In terms of the SPA comments, we have provided a response in red to each of the three points below:

Refuse Vehicle Entering Site

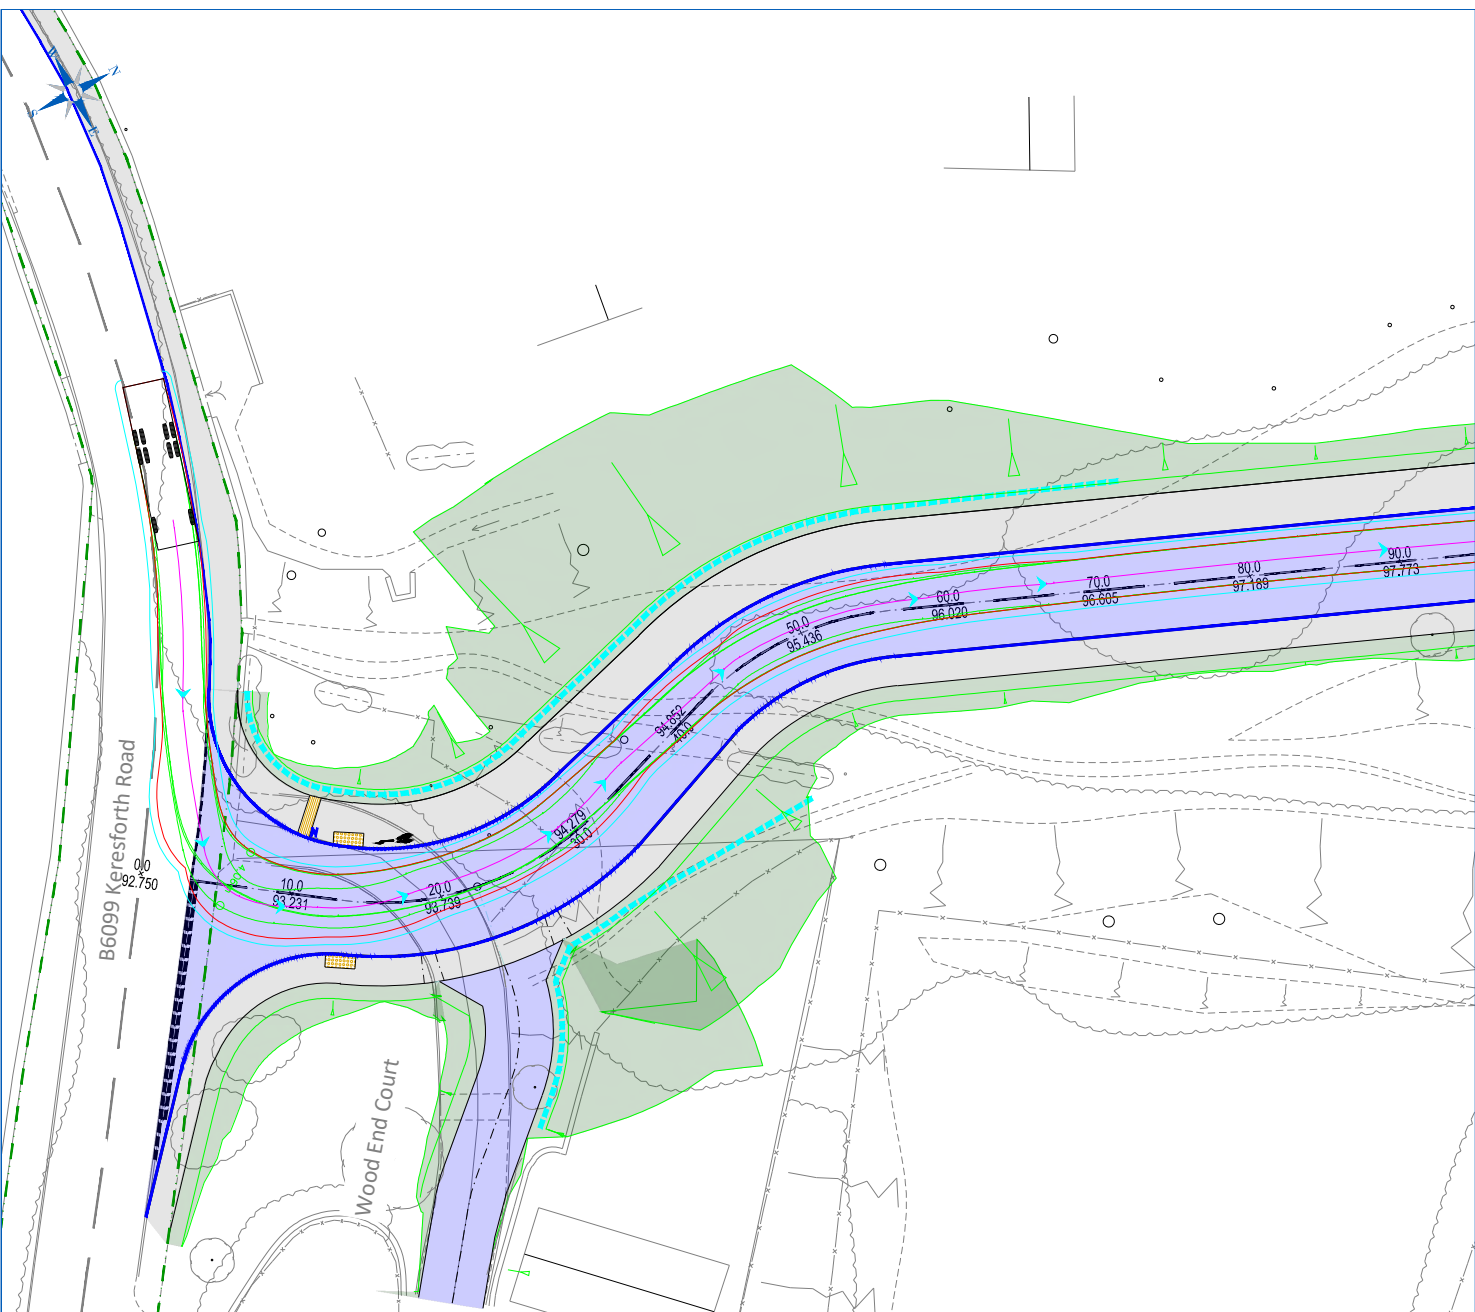
- *A 0.5m gap from the edge of Keresforth Road is not maintained (drawing “Refuse Vehicle Entering Site”).* LTP Response: This is due to the existing alignment and carriageway width of Keresforth Road and is consistent with the movements of existing refuse vehicles travelling along Keresforth Road including those which currently serve Wood End Court. The proposed access arrangements provide a betterment to the existing situation in terms of refuse vehicle movements as vehicles are not required to encroach the opposite side of the carriageway when turning in and out of the proposed access compared to the existing Wood End Court junction.

Refuse Vehicle Exiting Wood End Court

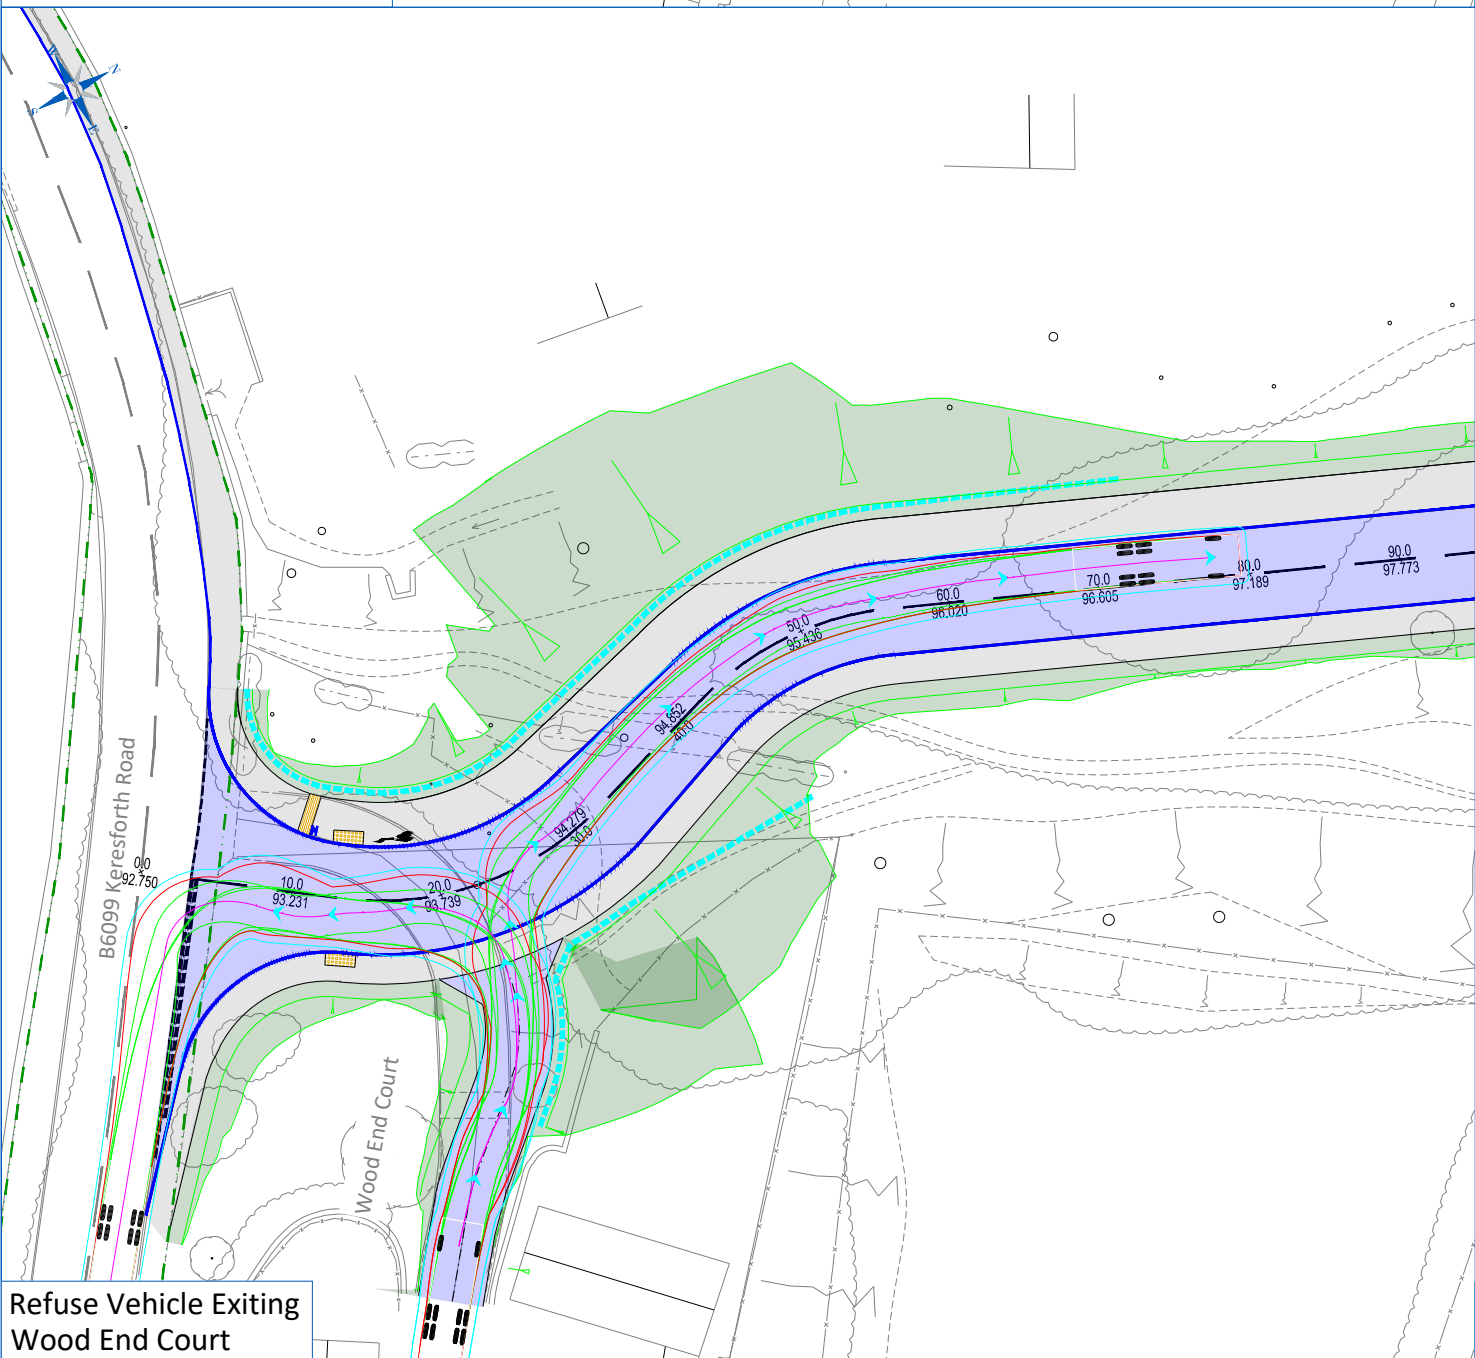
- *The vehicle overhangs and overruns the verge on Wood End Court (drawing “Refuse Vehicle Exiting Wood End Court” and “Refuse Vehicle Exiting Wood End Court”).* LTP Response: There is no verge overrun by the refuse vehicle when entering and exiting Wood End Court. The cyan line shown on the swept path is the 0.5m buffer with the outer wheel track fully within the extents of the carriageway.
